## 169 Newbury - outstanding items

David Senus <[dsenus@woodardcurran.com](mailto:dsenus@woodardcurran.com)>  
To: Caitlin Cameron <[ccameron@portlandmaine.gov](mailto:ccameron@portlandmaine.gov)>

Tue, Mar 29, 2016 at 3:20 PM

DETAILS - ROOF

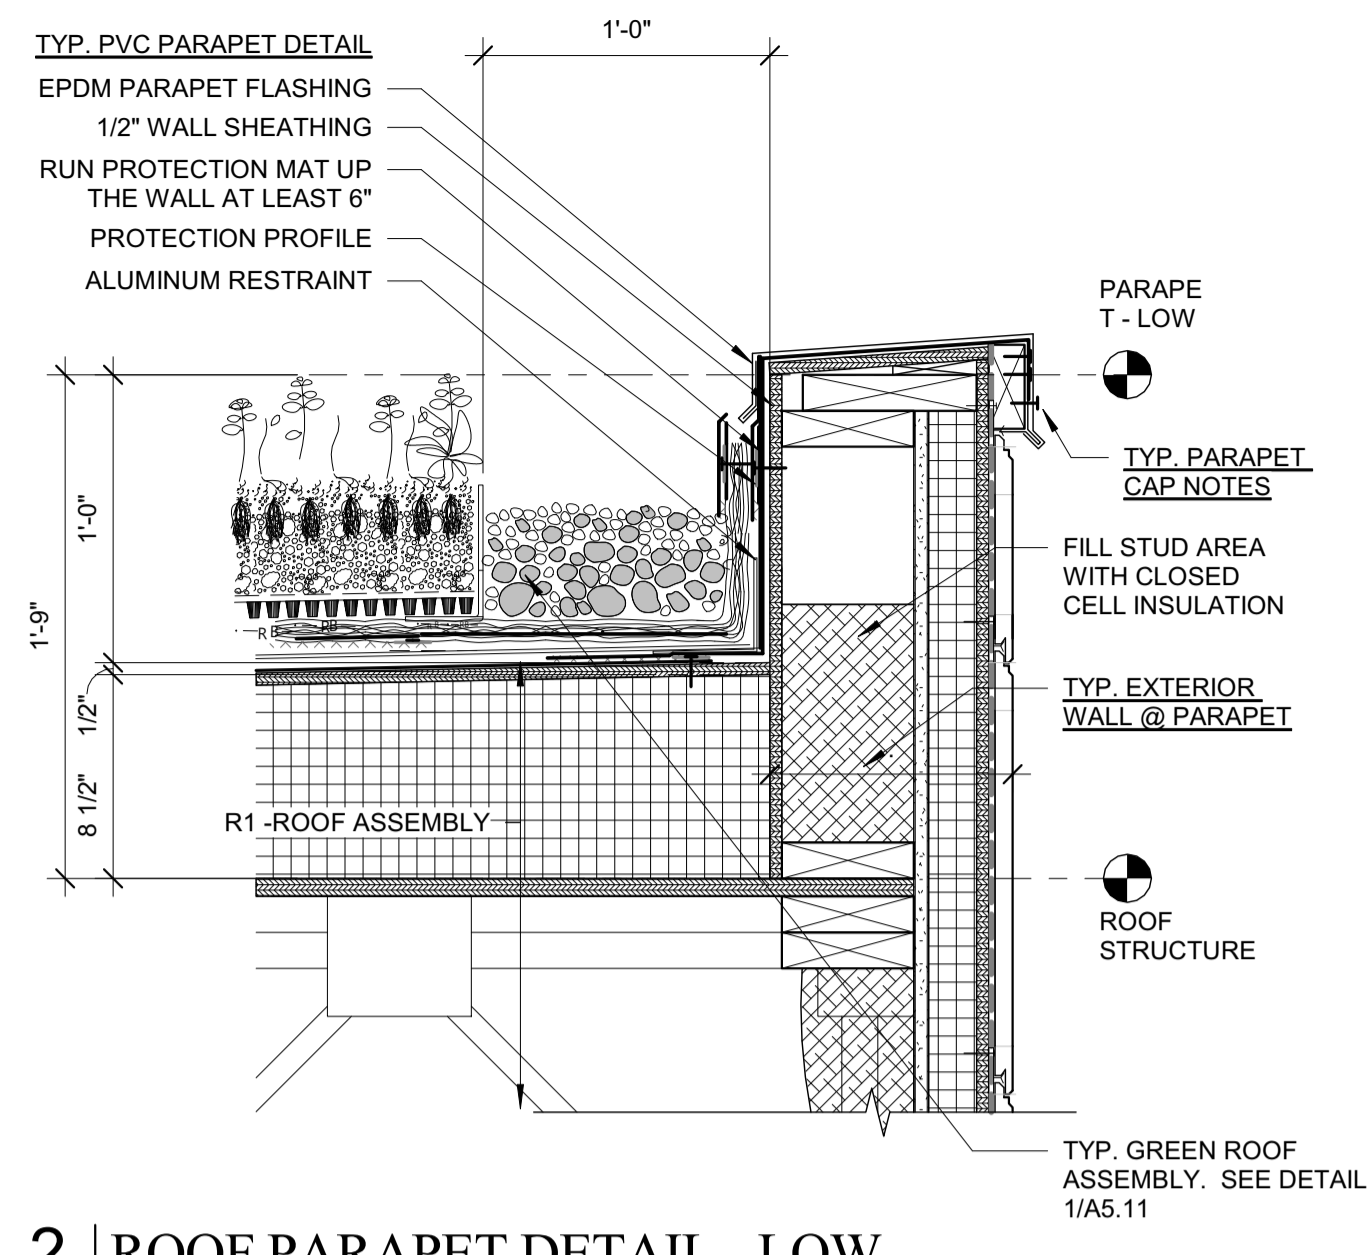
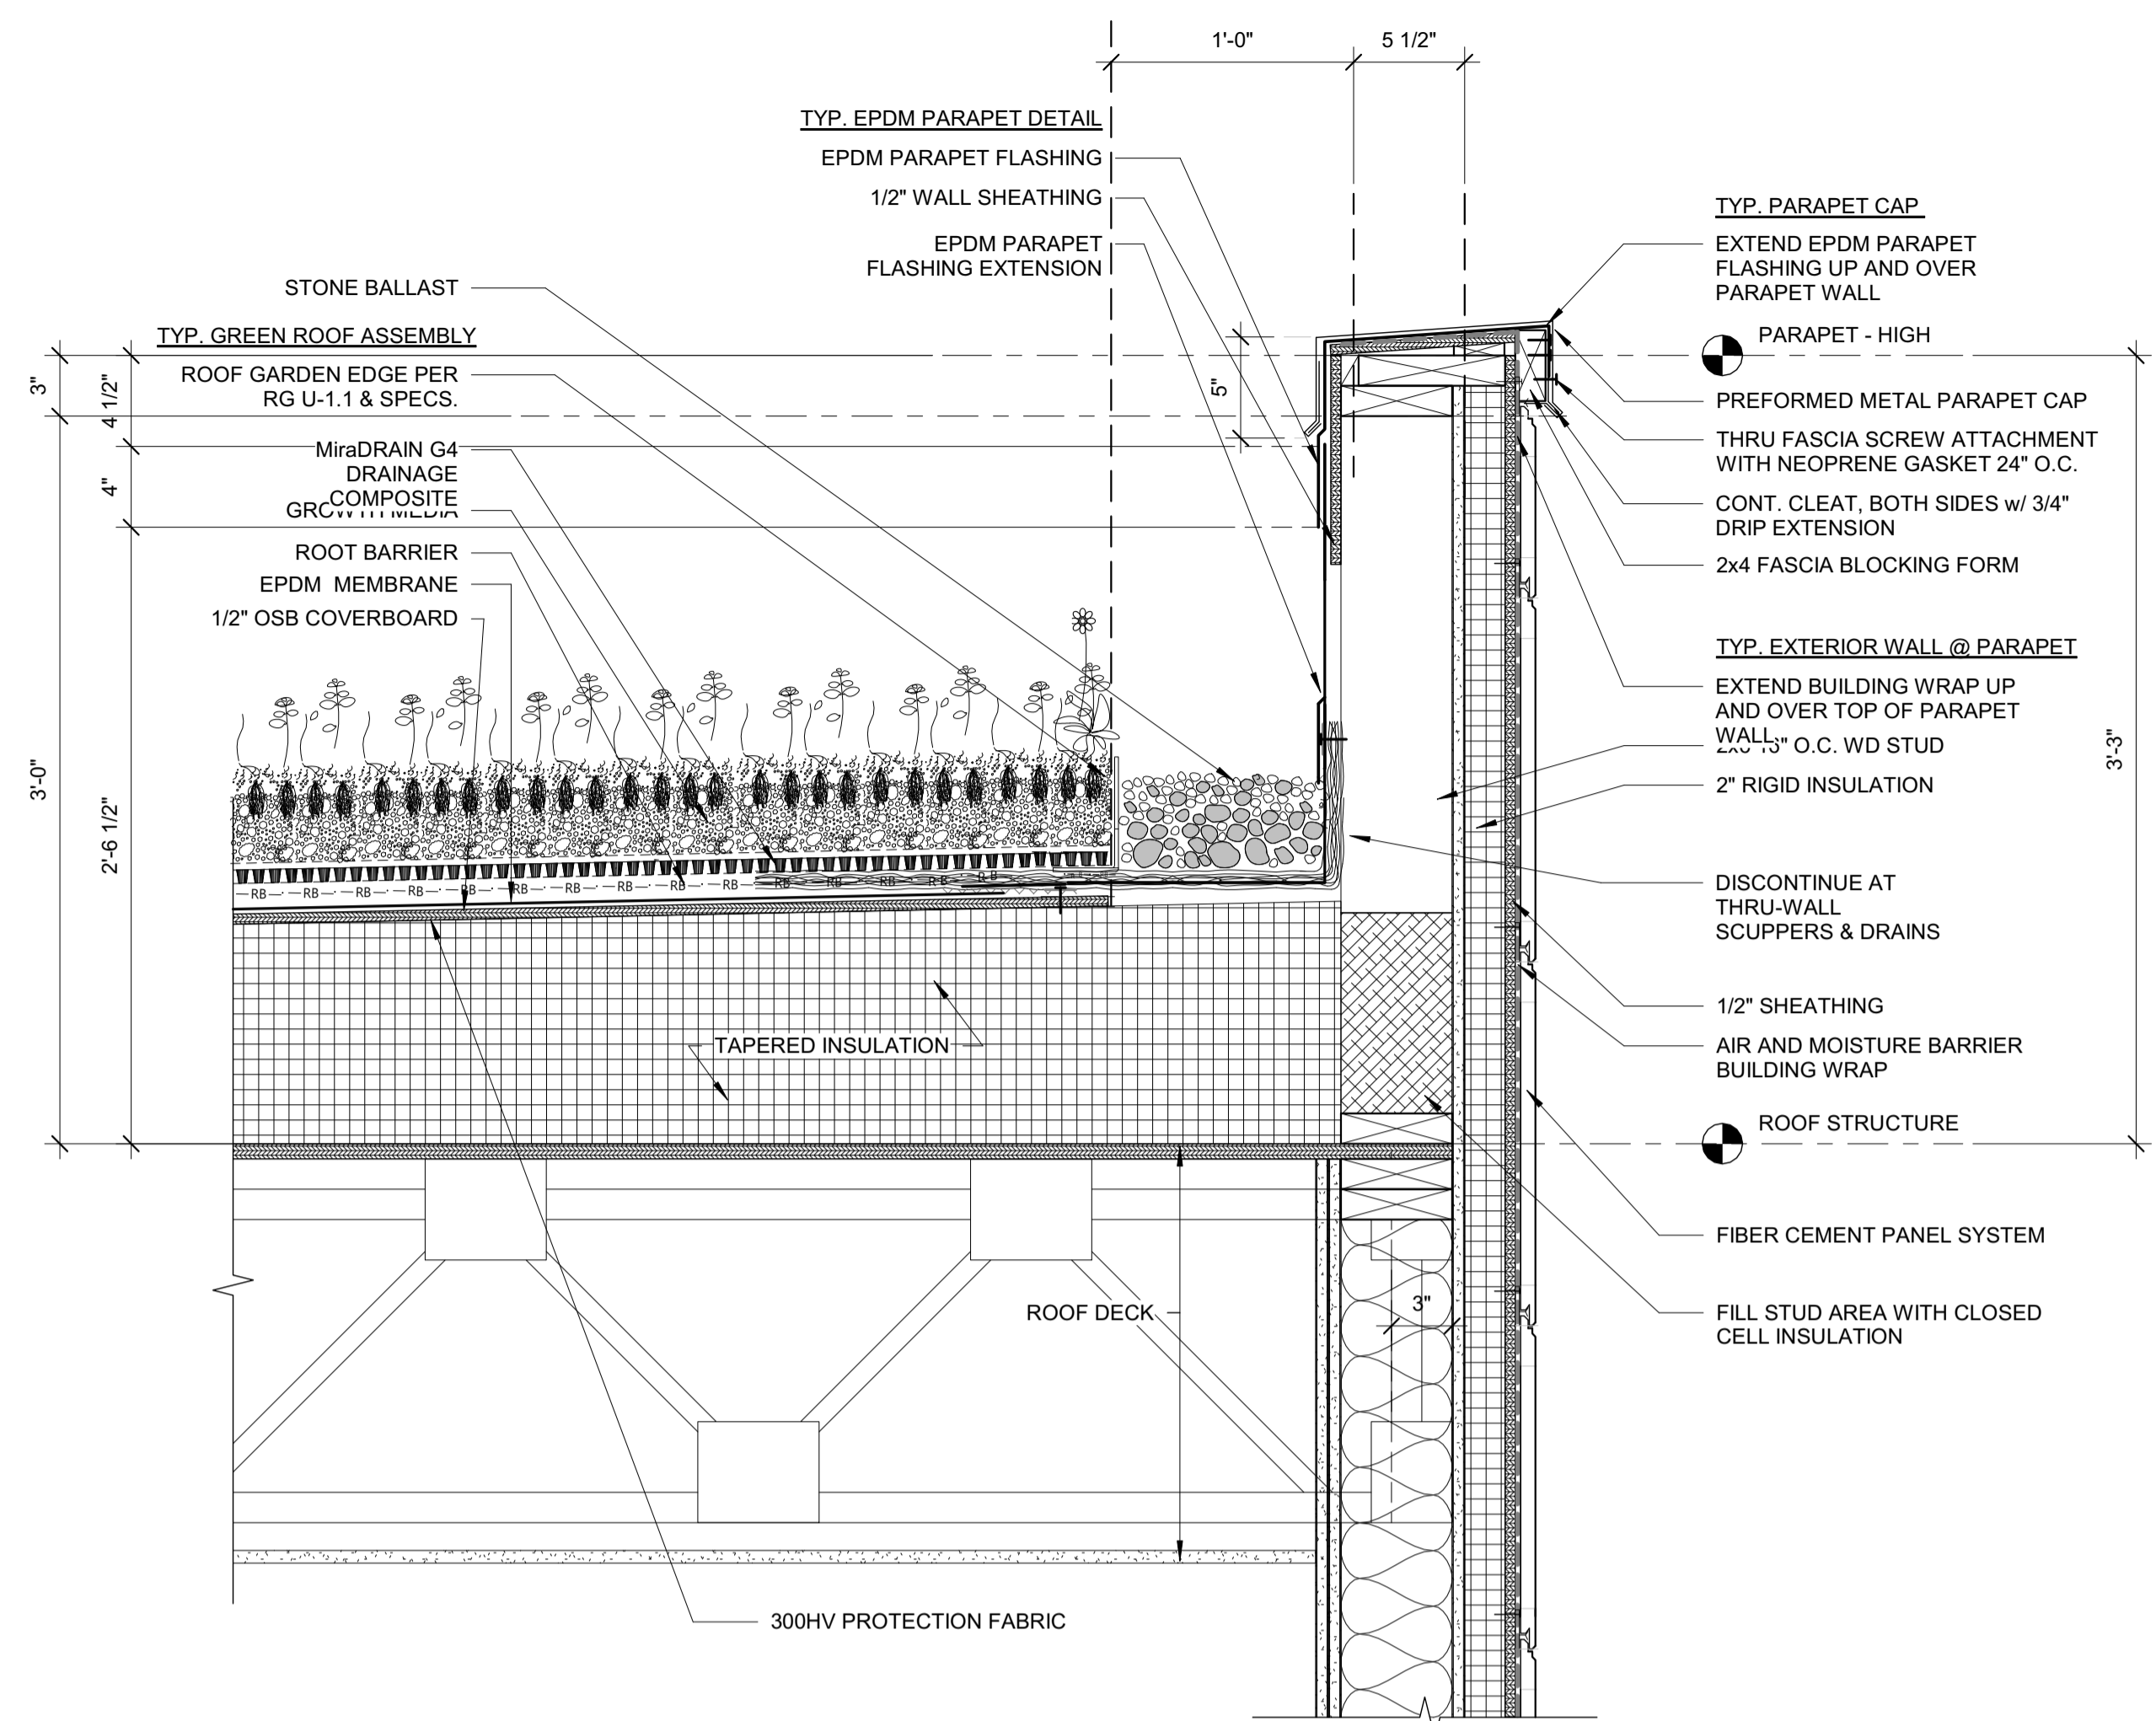
I received the roof details, but I was anticipating see a green roof plan (plan view, more detailed than A0.2) and green roof-specific detail(s) that identifies specific info for the green roof system (depths of each component, how drainage layers tie into the building drains, etc). The submitted roof details focus on parapet construction.

**8 | GREEN ROOF DETAIL AT 6TH FLOOR DECK**  
 1 1/2" = 1'-0"

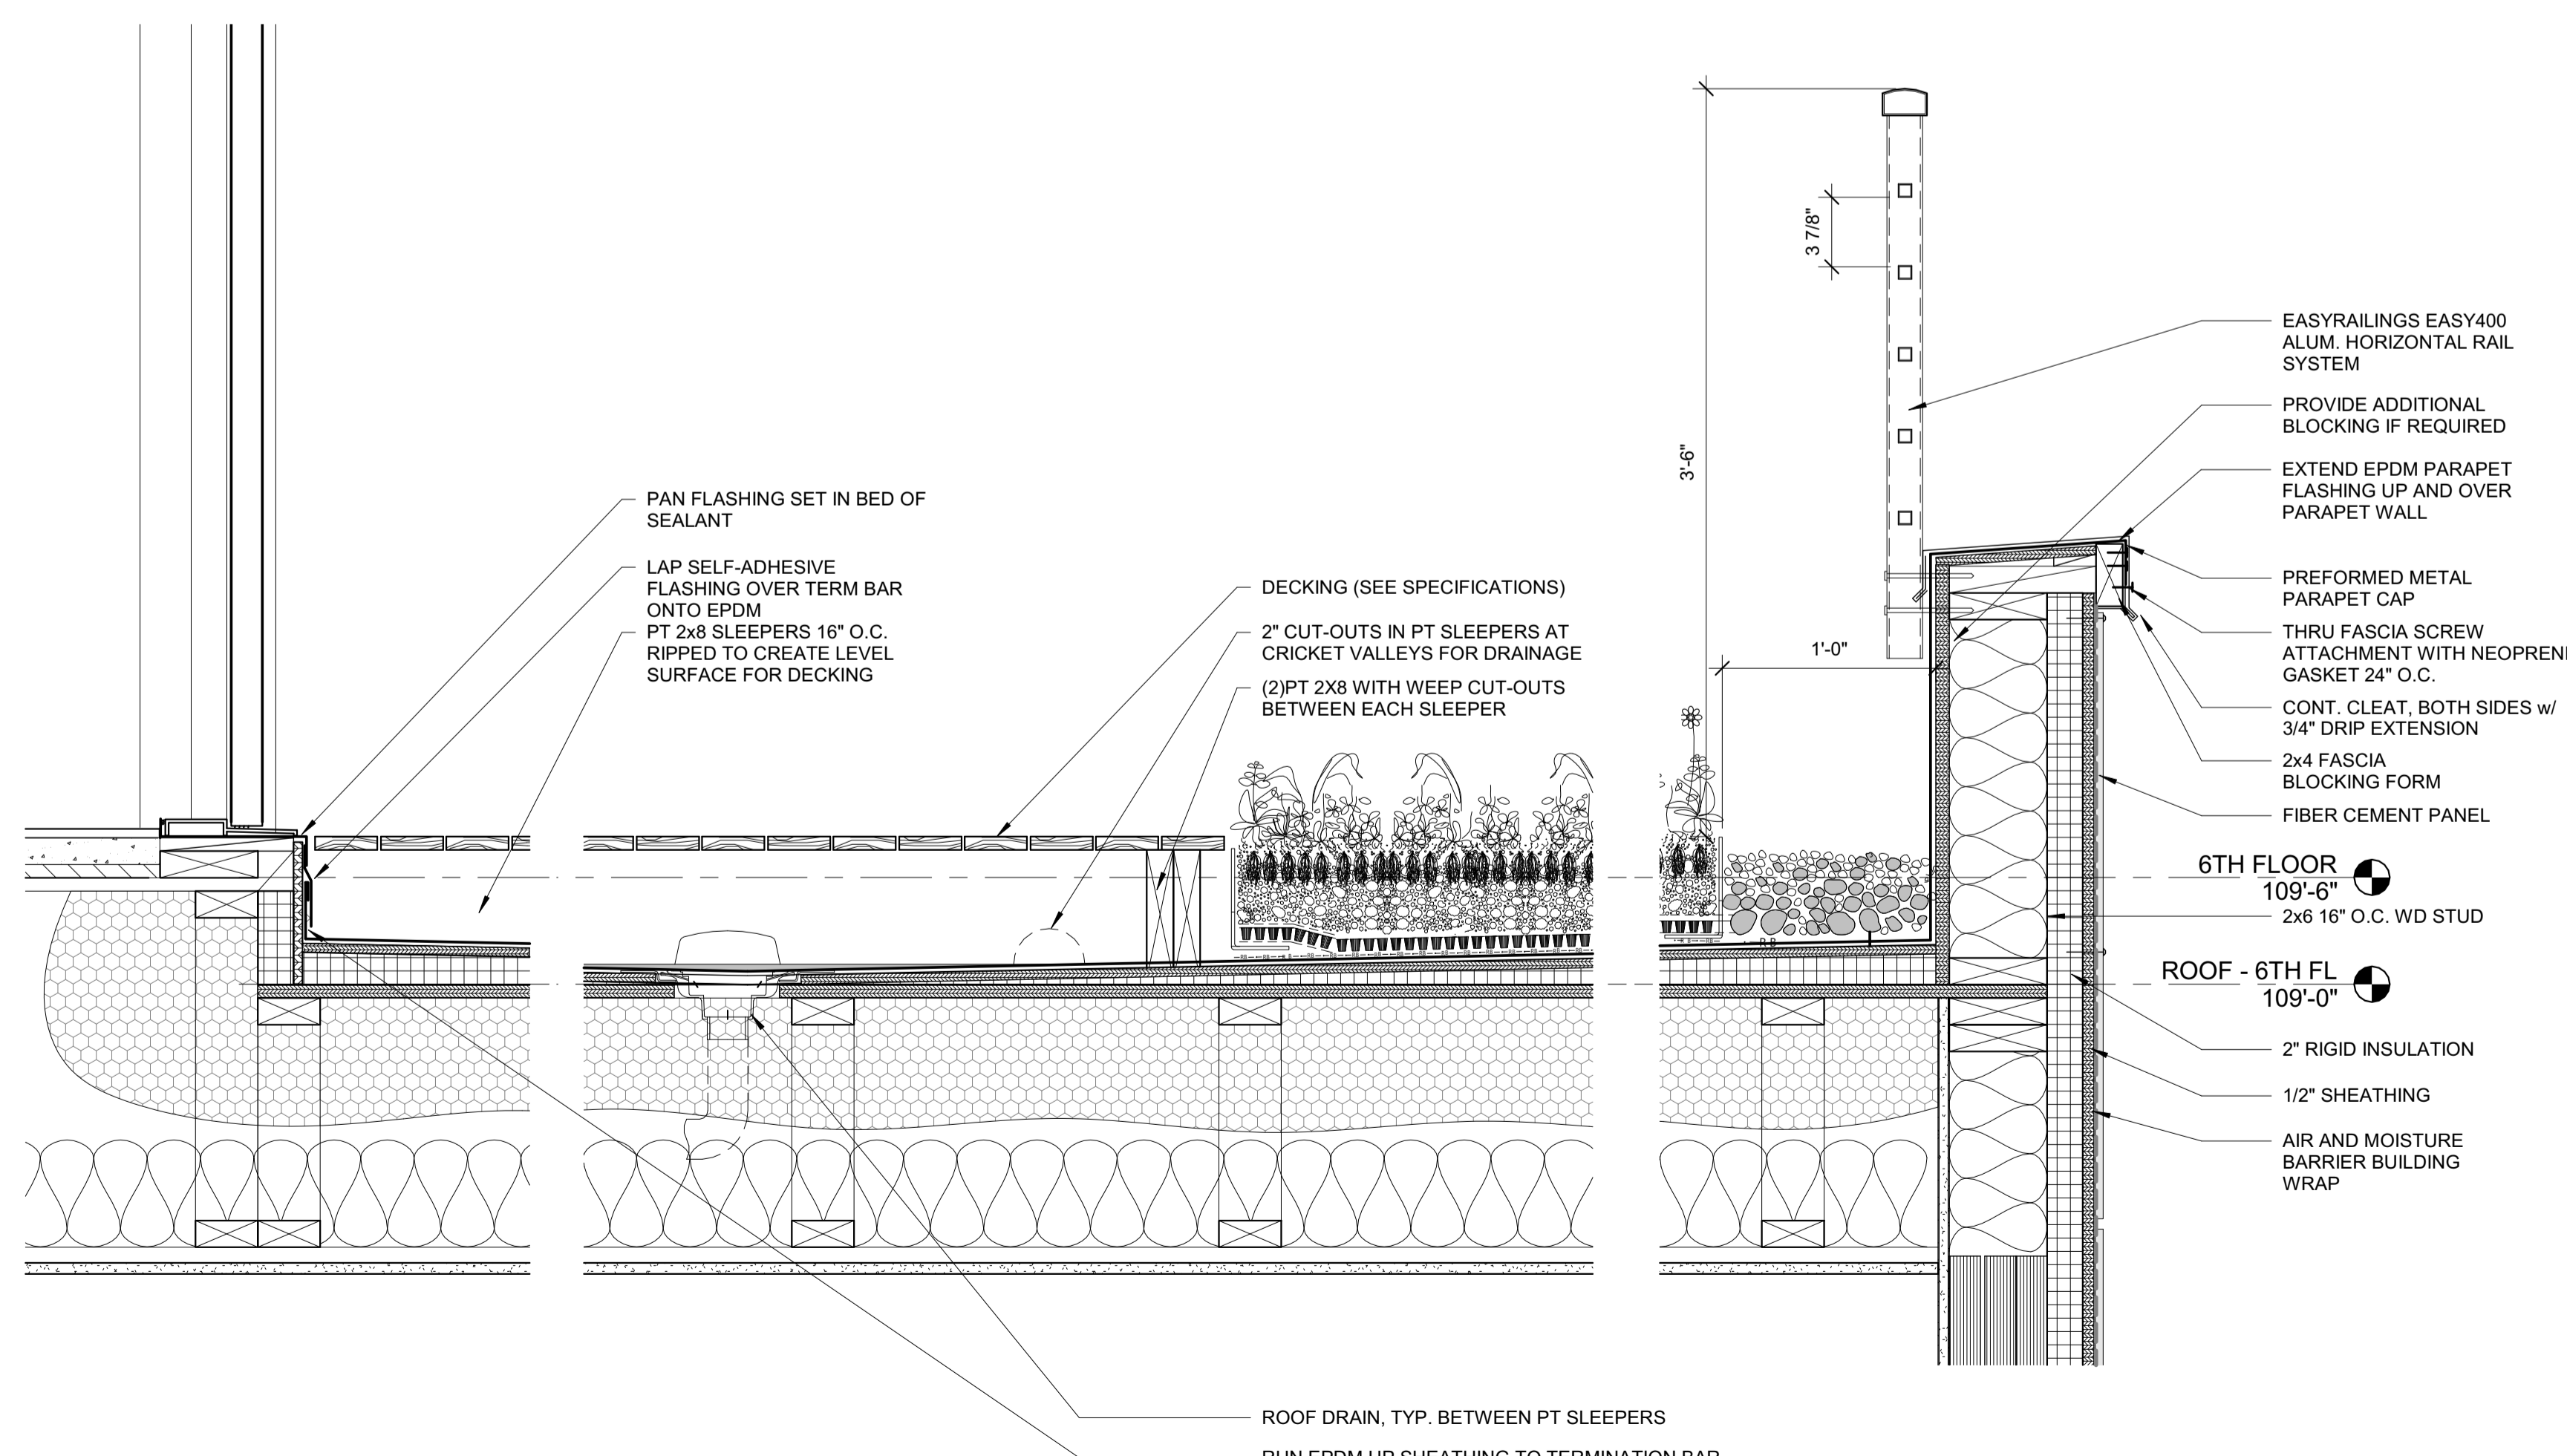
Can the system accept 1" of rainfall in 24" hours without bypassing and overflowing into the roof overflow drains? The applicant should provide calculations to show that the filtration rate of the green roof can manage the maximum rainfall rate of a 1", 24-hour, Type III storm event; this is all we can really go by to determine if the design is roughly compliant with MaineDEP criteria for filter systems.
